**WEST SUSSEX COUNTY COUNCIL
STRATEGIC PLANNING CONSULTATION**

DATE: 13th November 2015

SUBJECT: AL/91/15/PD - Prior approval for change of use from cattle and storage barn (Agricultural building) to 1 no 3 bedroom dwelling (class C3).

**The Old Piggery(Cattle and Storage Barn), Beechfield Park, Aldingbourne,
PO20 3TT**

SITE PLAN

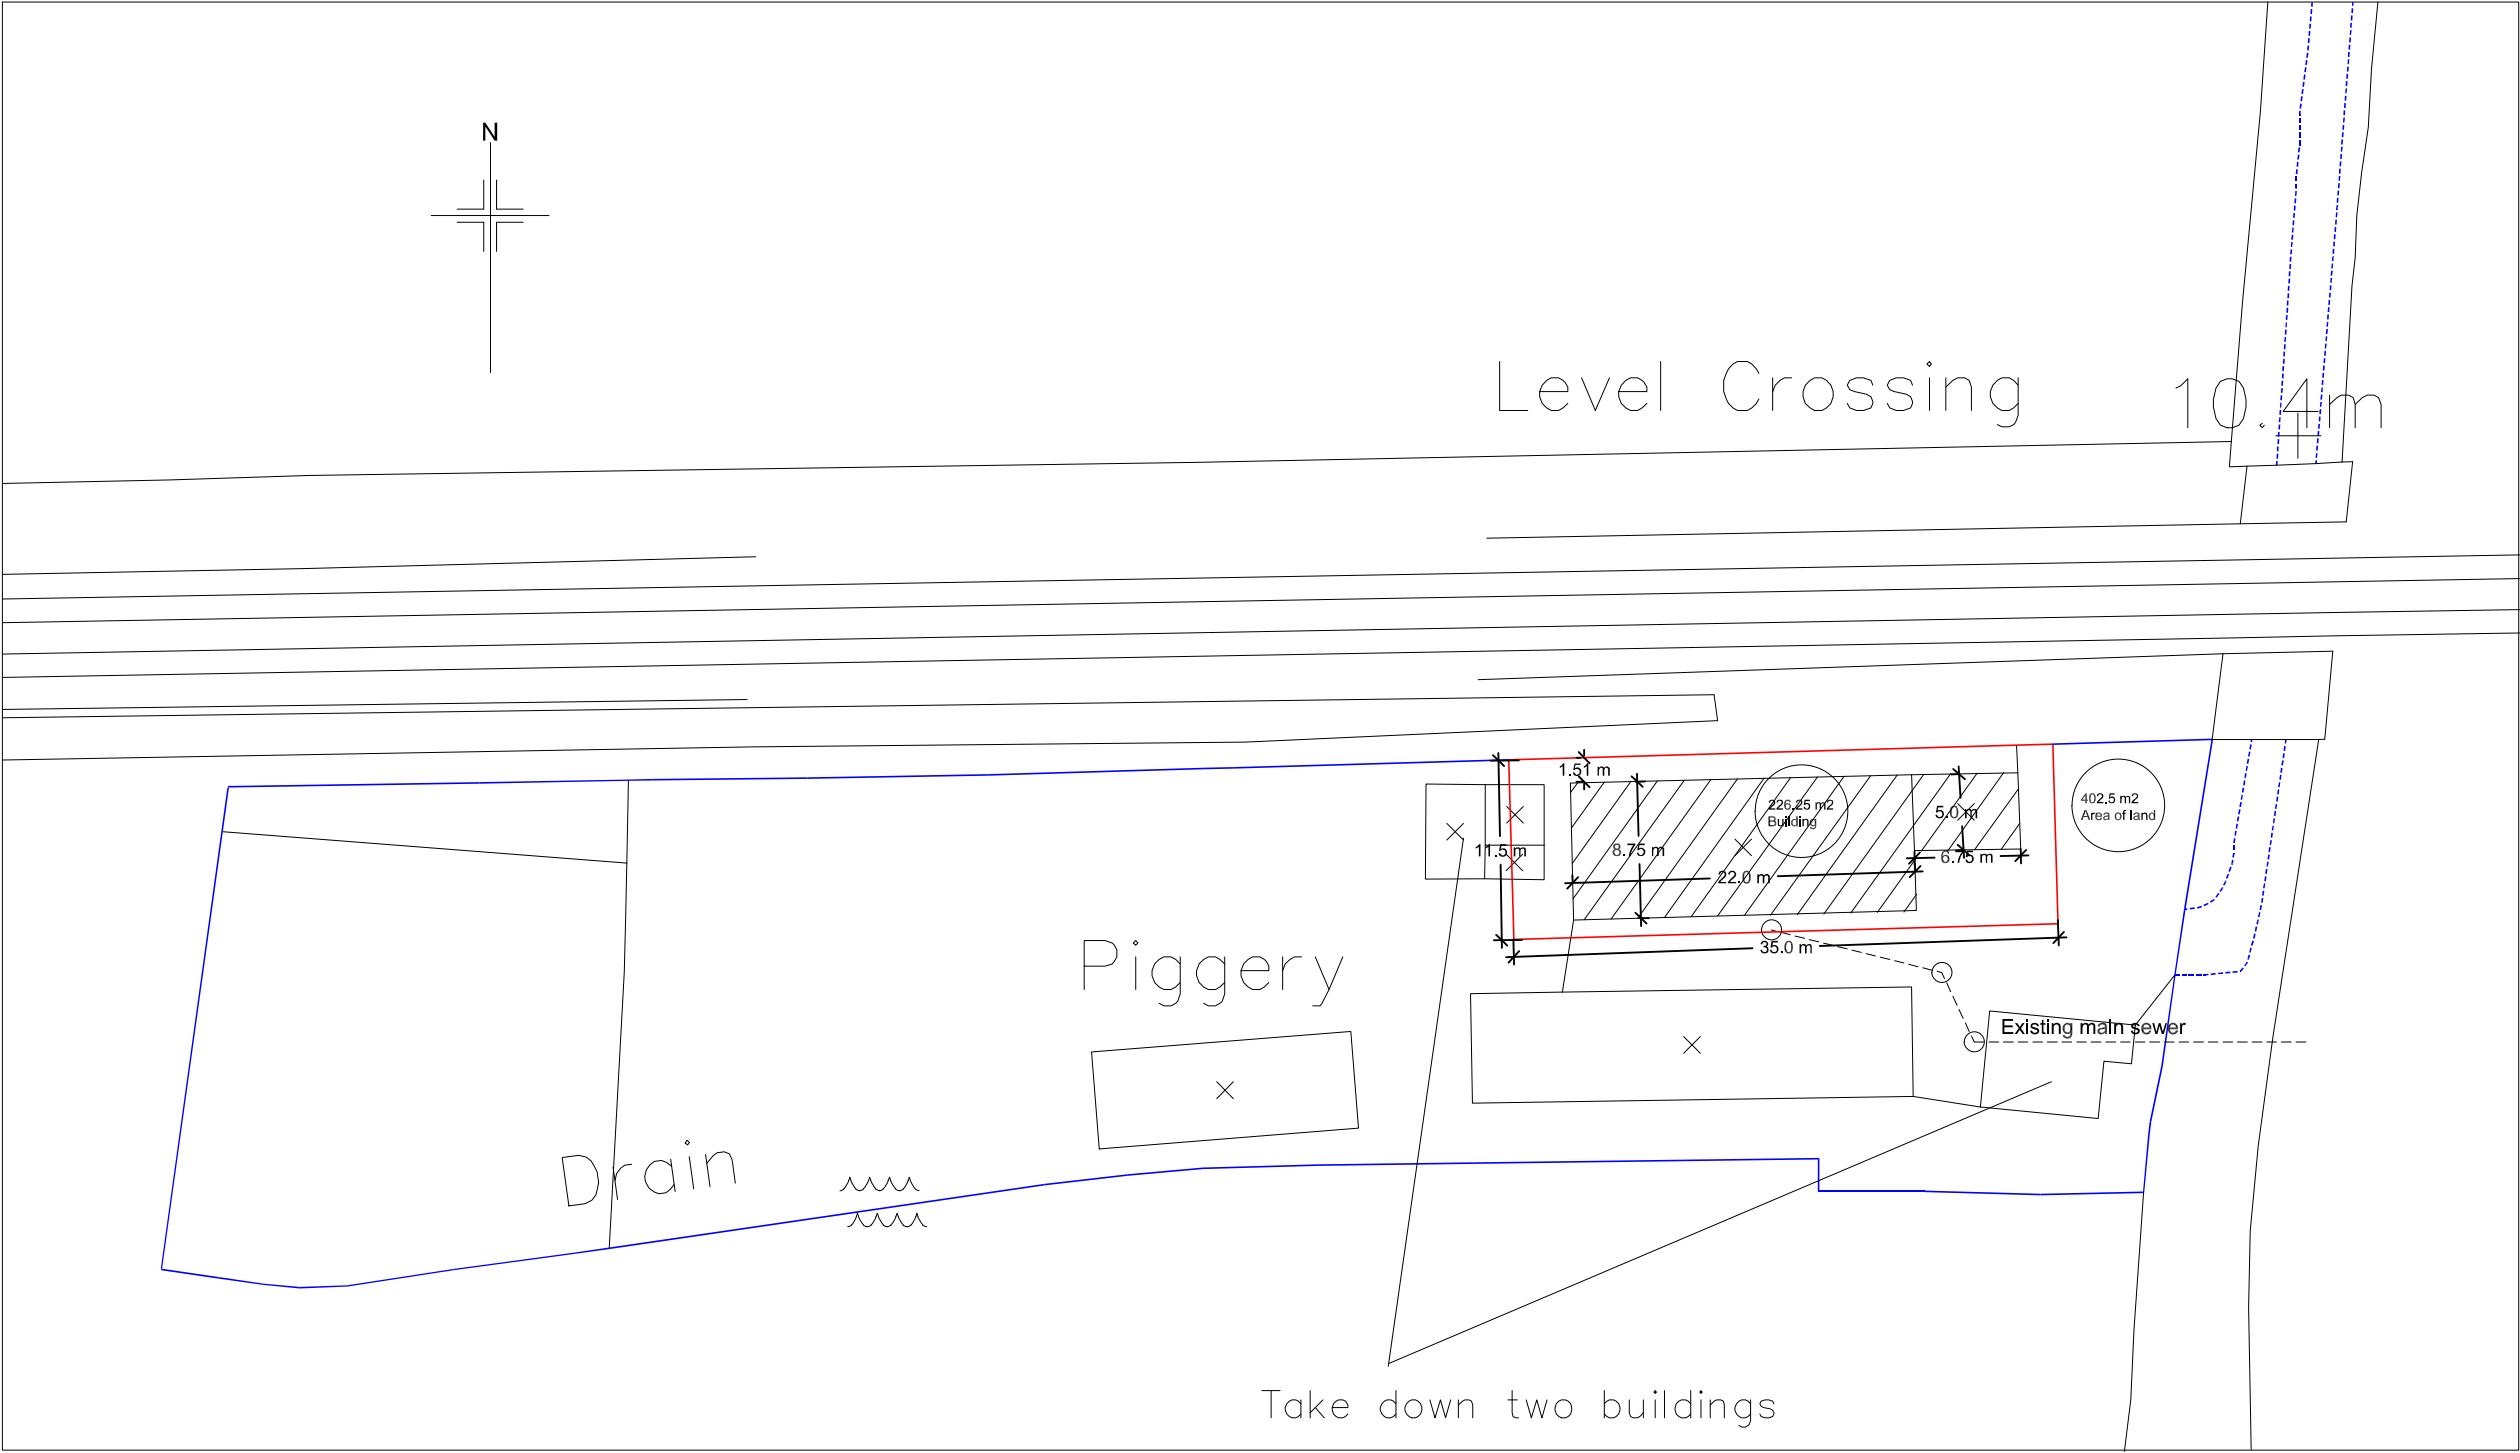
The proposal is for the prior notification of an existing agricultural unit into a single residential unit with access onto the publicly maintained network at Hook Lane via an existing access point. From an inspection of the plans alone, there is no apparent visibility issue at the point of access onto Hook Lane. Please note that this application involves a level crossing to the nearest Highway, Network Rail should be consulted if not already done so.

No part of the development shall be first occupied until covered and secure cycle parking spaces have been provided in accordance with plans and details submitted to and approved by the Local Planning Authority.
